# **Boston Alternative Energy Facility**

## **Statement of Common Ground between Alternative Use Boston Projects Limited and the Environment Agency**

**Planning Inspectorate Reference Number: EN010095**

**Date: February 2022**

View 3: Looking west from Footpath (Fish/3/1) at Fishtoft

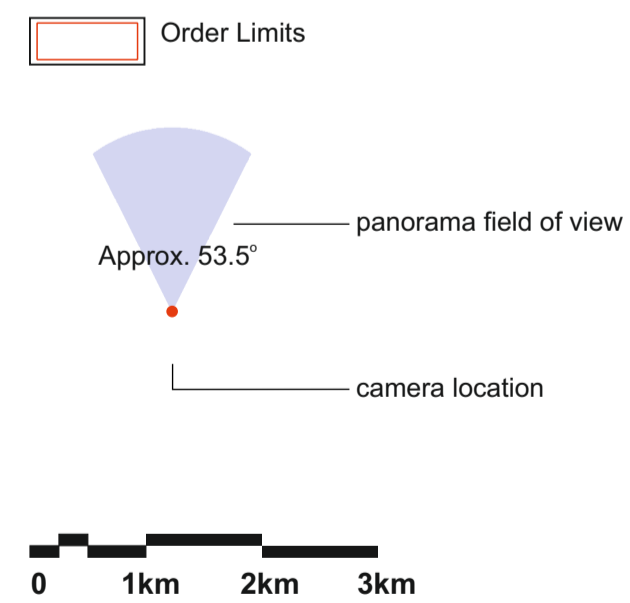
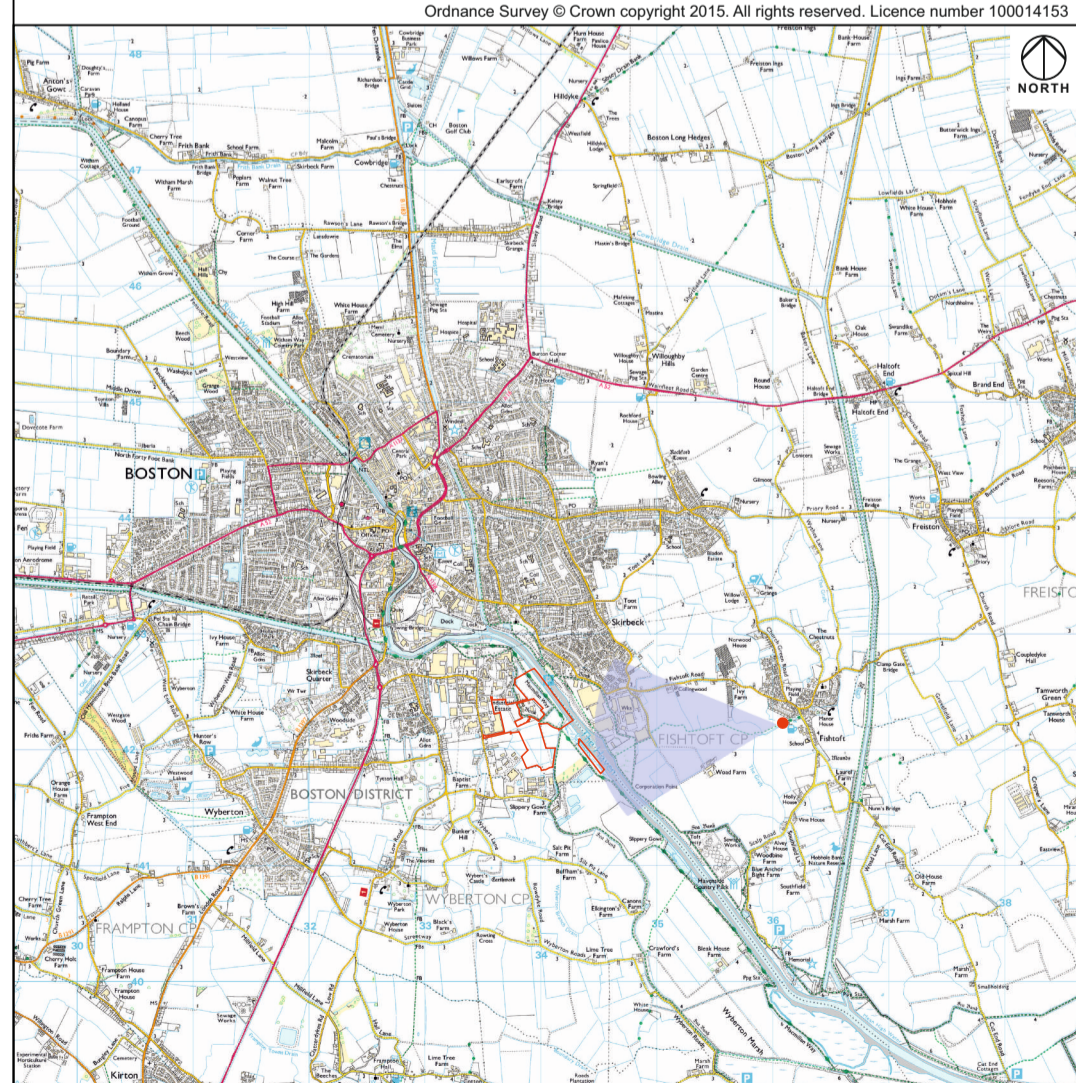
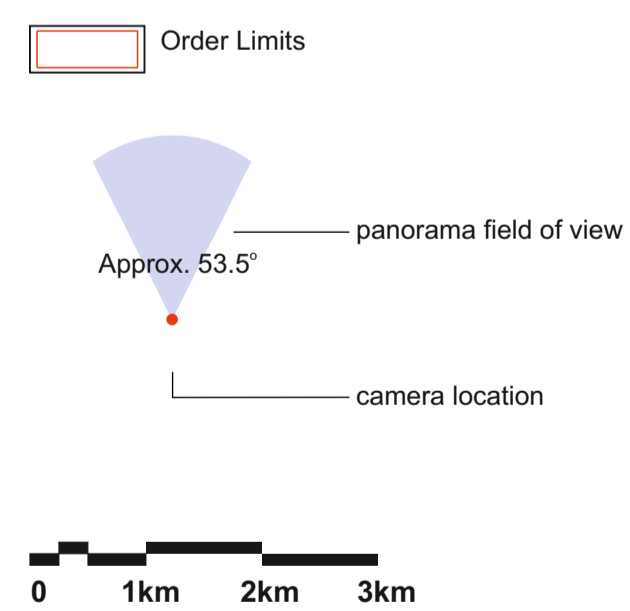
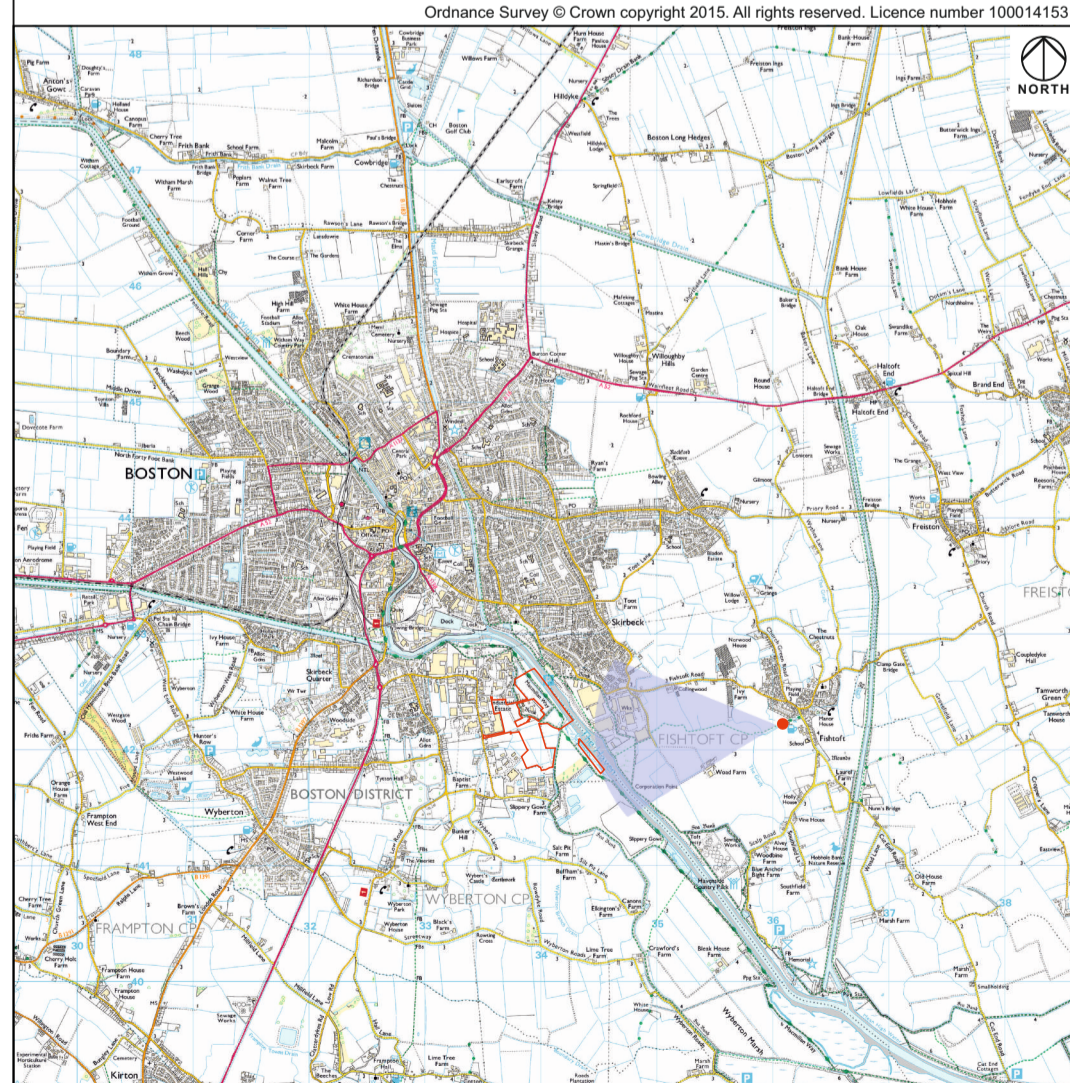
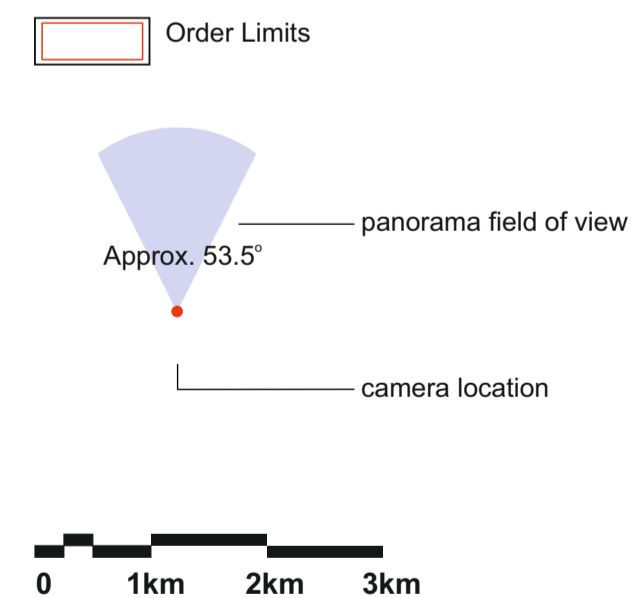
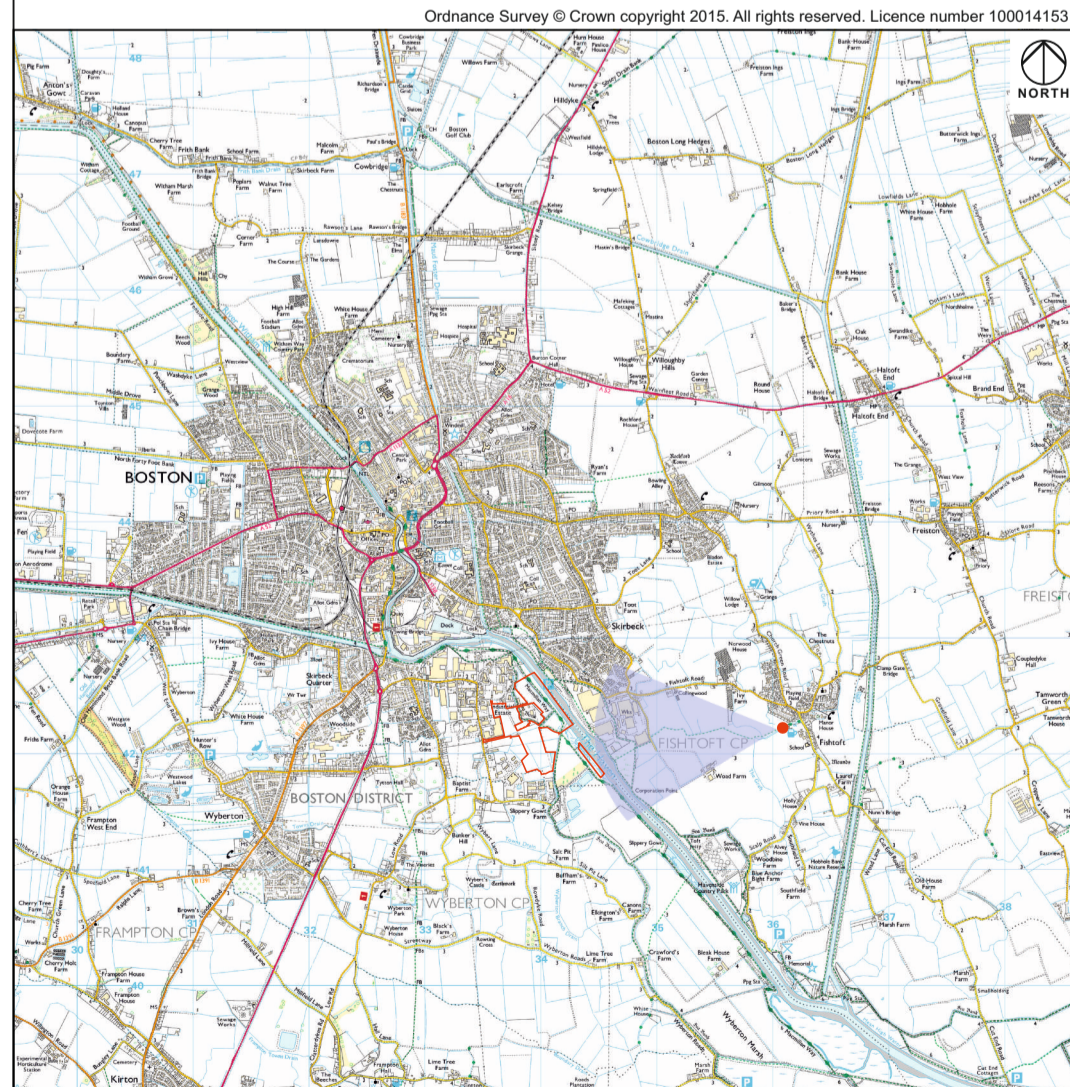
SoCG Reference	Document Reference	Topic	EA's Comment	AUBP Response	Status
9.0 Landscape and Visual Impact Assessment					
EA 9.1	Chapter 9 Landscape and Visual Impact Assessment (document reference 6.2.9, APP-047)	Landscape and visual impact assessment	<p>The EA notes further information is needed on visible plumes.</p> <p>The EA notes a large visual impact on the landscape.</p> <p>The EA acknowledges that the information submitted is consistent with what it would expect to see from this type of process.</p>	<p>Further information on visible plumes was provided within documents submitted at Deadlines 1 and 2 including an updated Chapter 9 Landscape and Visual Impact Assessment (LVIA) (document reference 6.2.9(1), REP1-004) and Chapter 14 Air Quality (document reference 6.2.14, REP1-006) and updated photomontages (document reference 6.3.7(1), REP2-017 and document reference 6.3.9(1), REP2-019).</p> <p>The LVIA identifies significant, irreversible adverse visual effects upon certain visual receptors. Effects upon wider landscape character from visible plumes are lessened due to the existing baseline and presence of industrial and infrastructure features.</p>	Agreed
